Objection to planning application for residential development to the east of no 28, Northorpe Lane, Mirfield WF14 0QN

Reference 2021/62/91914/E

14-06-21

Drawing **Proposed Site Layout**

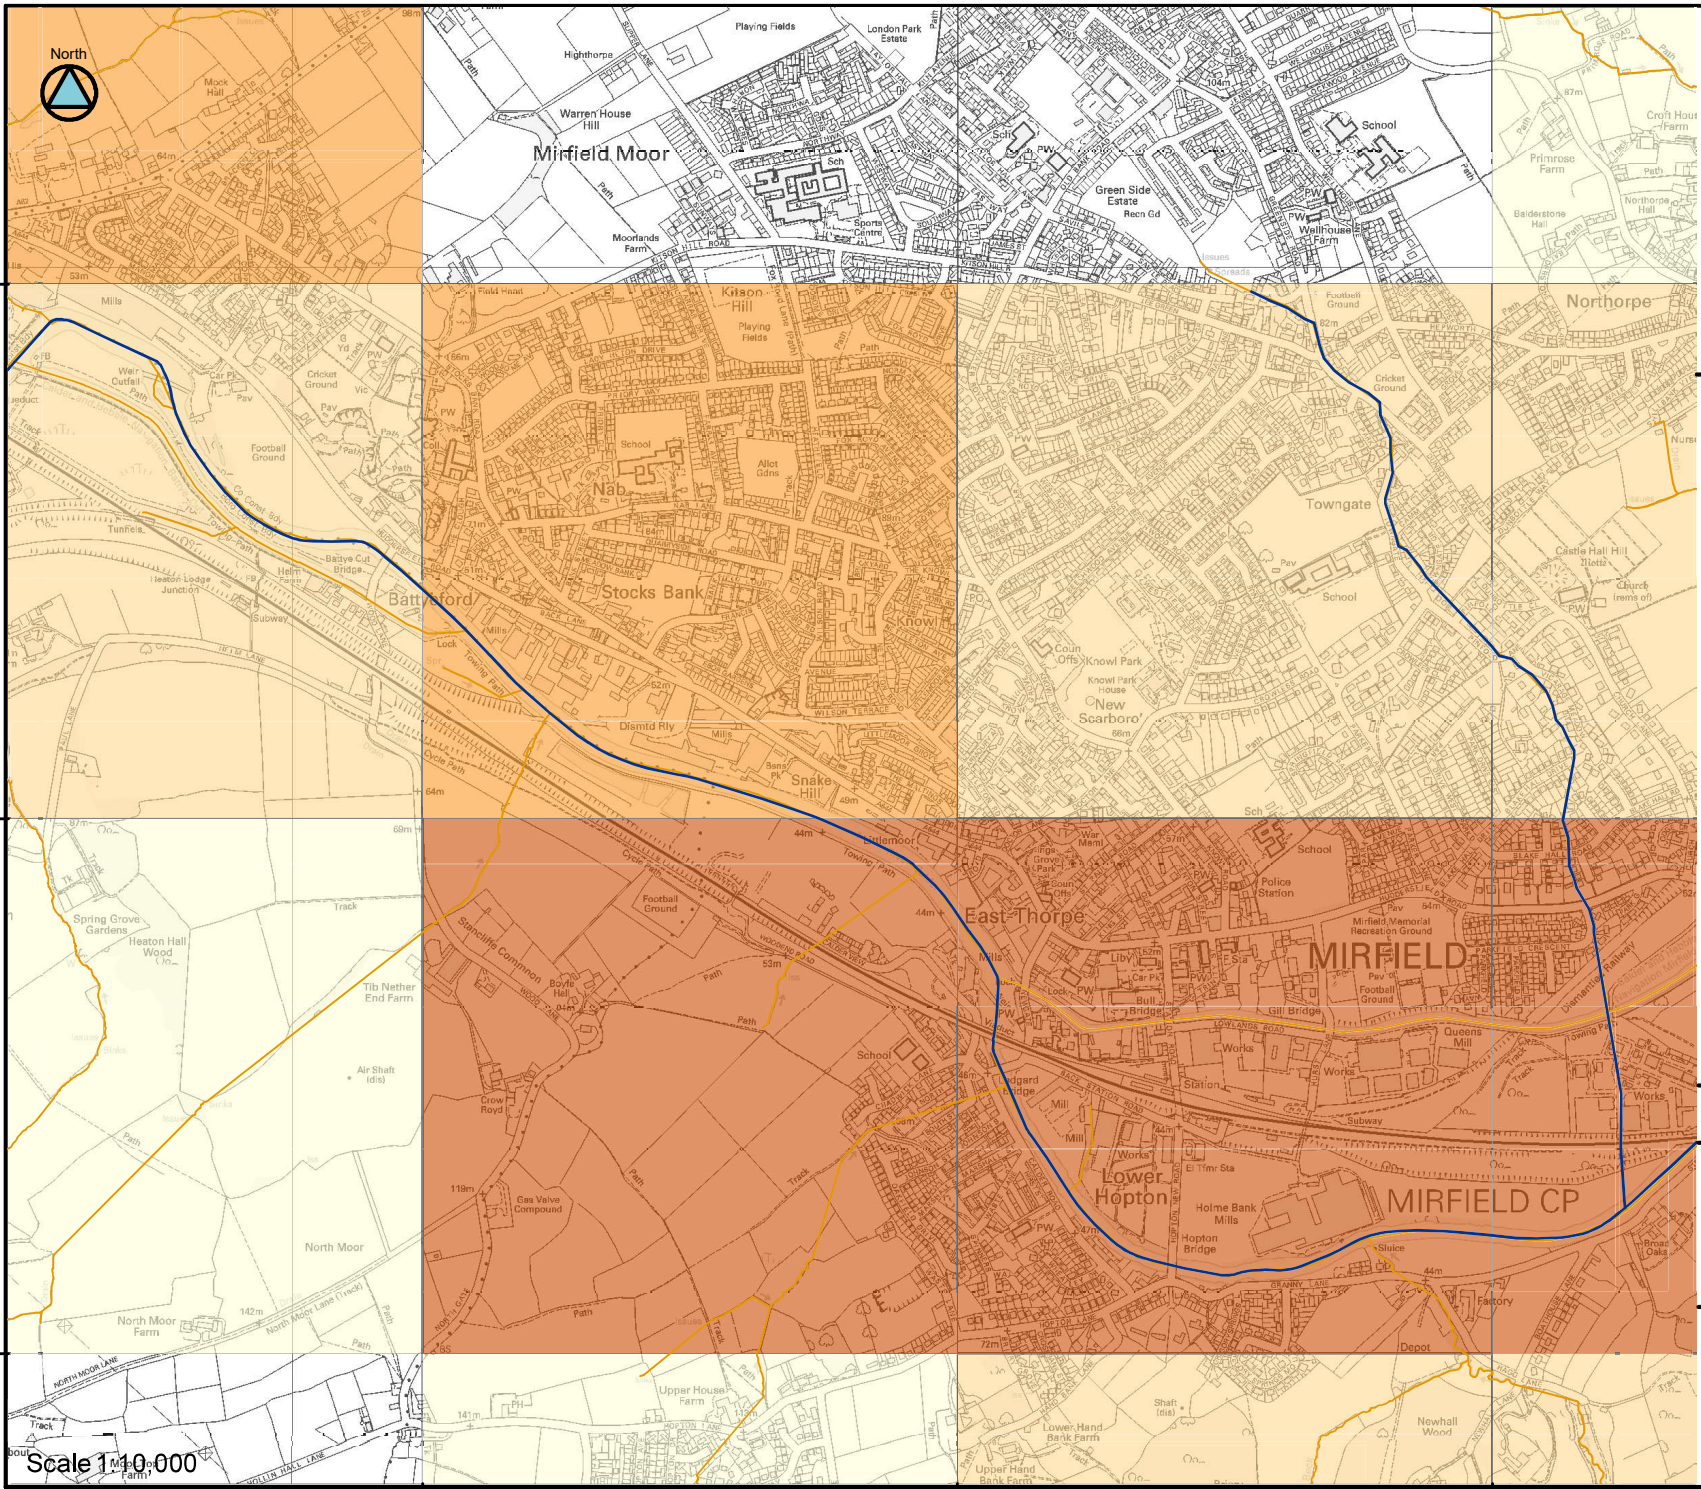
As the Southern Boundary of the development would border our garden and the houses on Northorpe Court, we want to have specific answers as to how the development is to be screened from view, given the close proximity to existing houses and gardens and the rural nature of the site.

We want to know exactly what provision is to be made for the planting of trees, shrubs, etc along the Southern Boundary in particular, and on the rest of the site in general, with the aim of absorbing water and screening existing properties from sight and noise.

The plan does not appear to have adequate provision for this.
